Rezoning Transportation Analysis
Petition Number: Insert Zoning Petition #2020-182
General Location Identifier: Tax ID 08019306

Revision Log:	Date	Description
	01-21-21	First Review (WB)
	03-25-22	Second Review (WB)

Transportation Summary

REZONING SITE PLAN

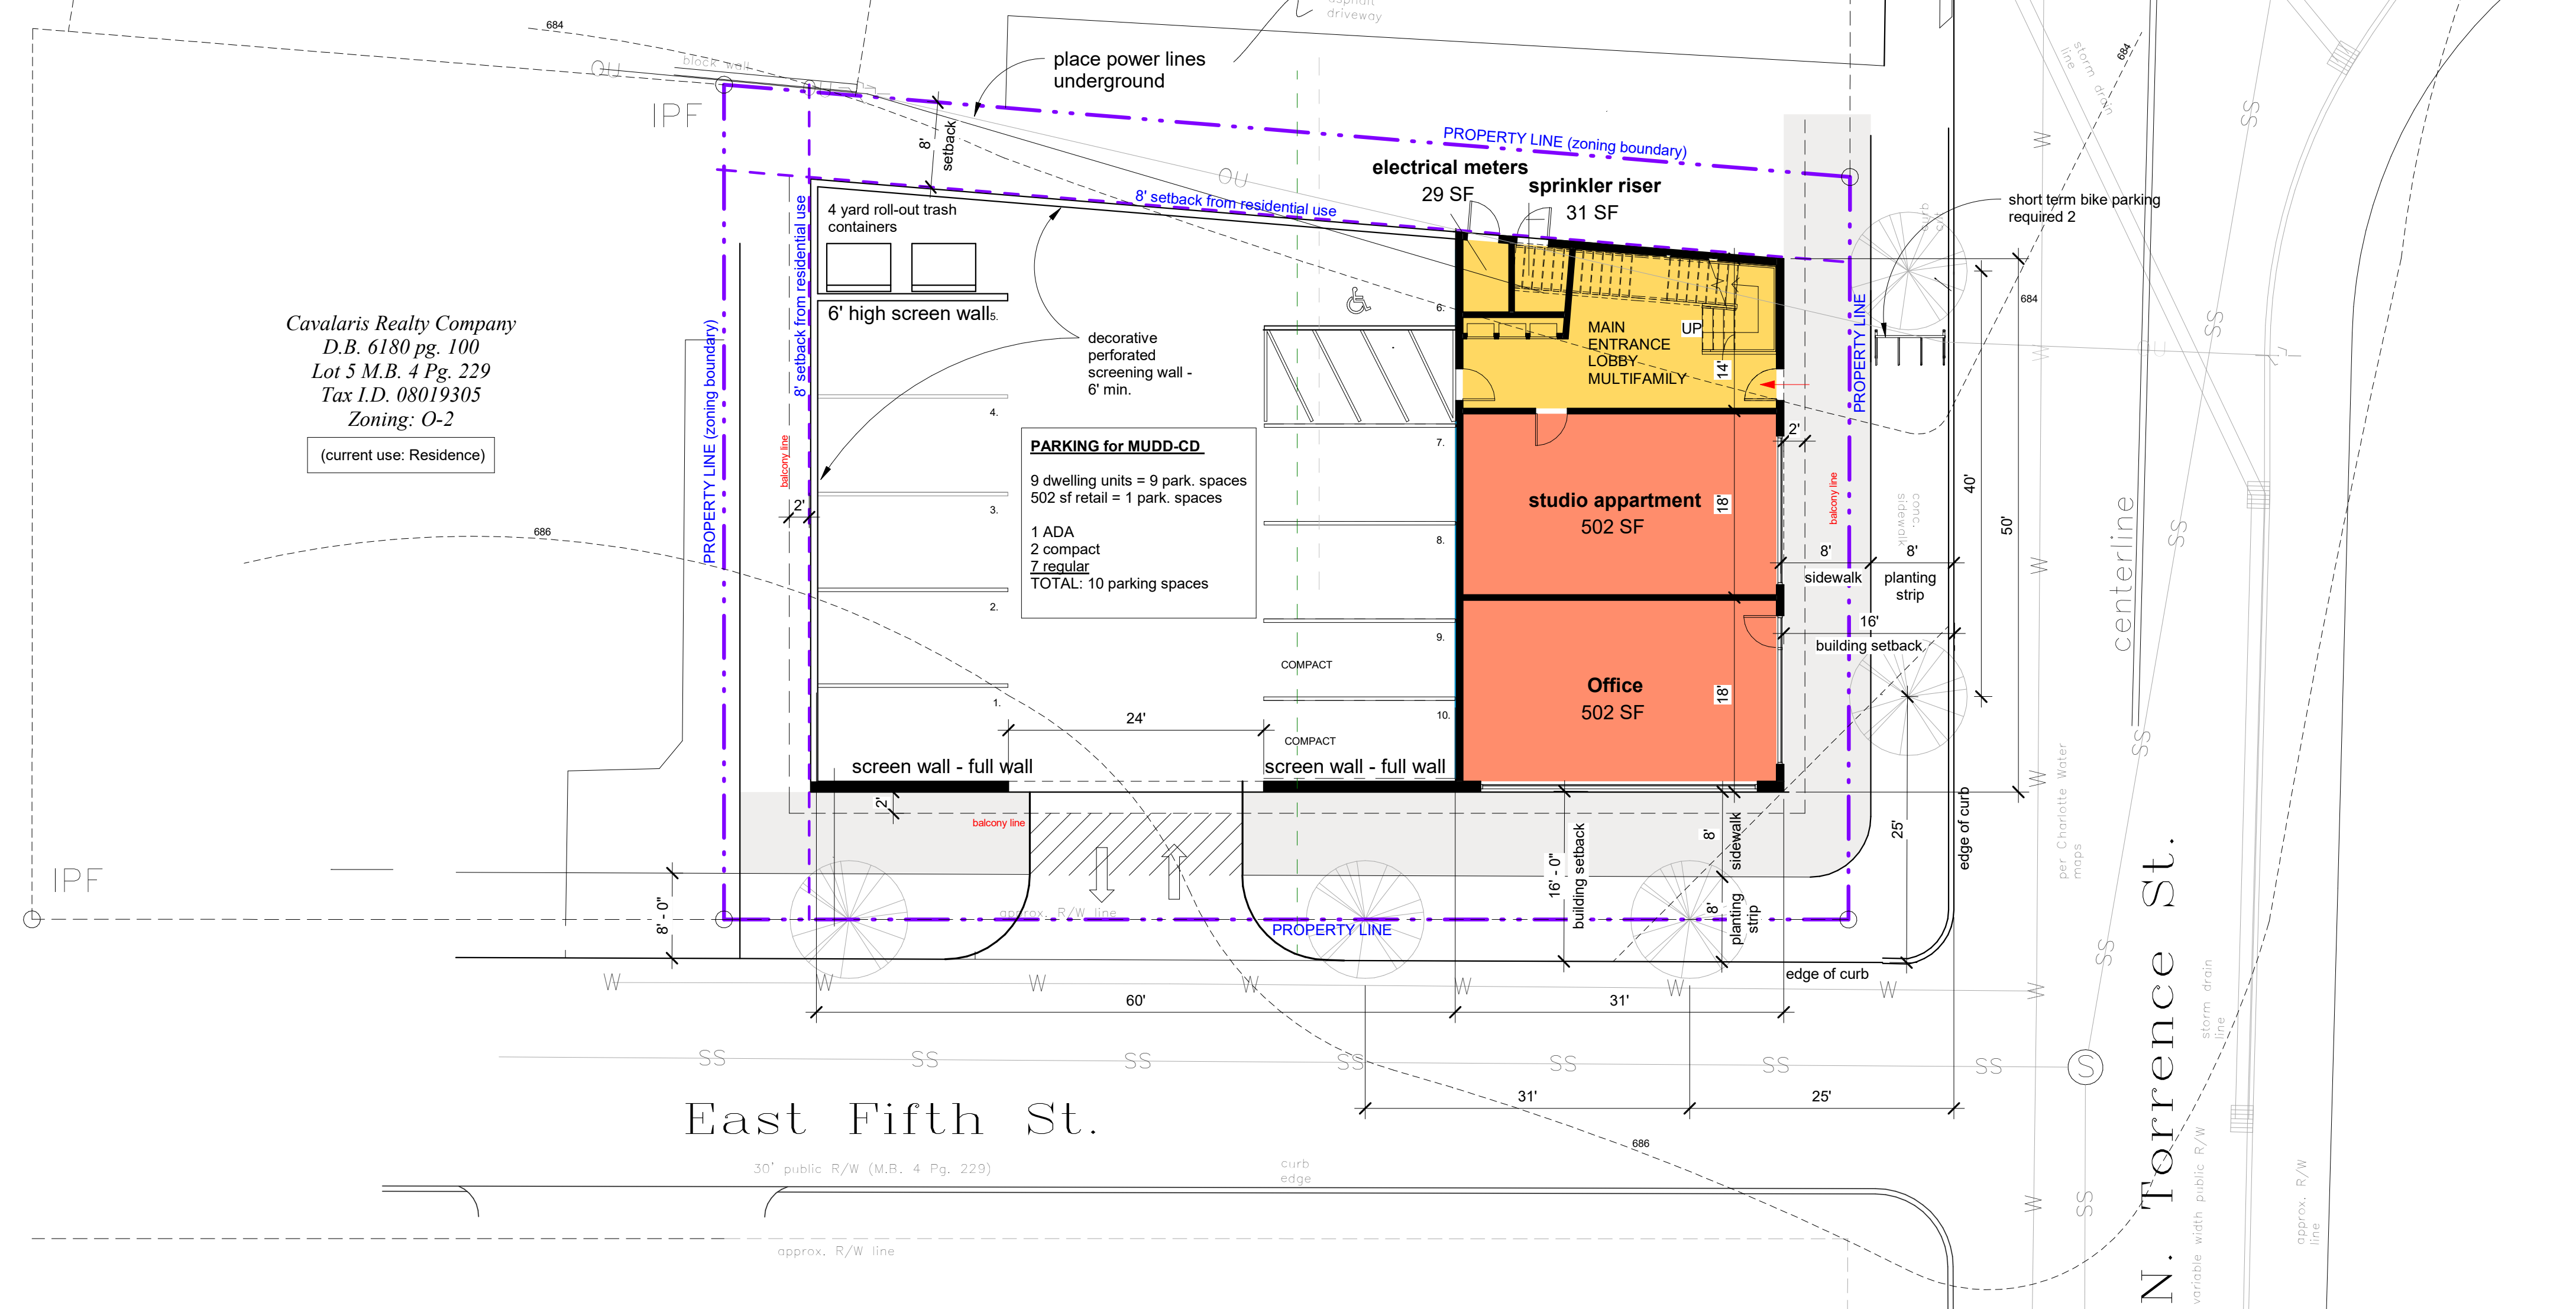
5. Add a site plan note specifying dedication and fee simple conveyance of all rights-of-way to the City before the site's first building certificate of occupancy is issued. CDOT requests rights-of-way set at 2' behind back of sidewalk where feasible.

6. Add a site plan note specifying that all transportation improvements will be approved and constructed before the site's first building certificate of occupancy is issued. The petitioner may phase transportation improvements if said improvements and phasing are explicitly described in site plan notes.
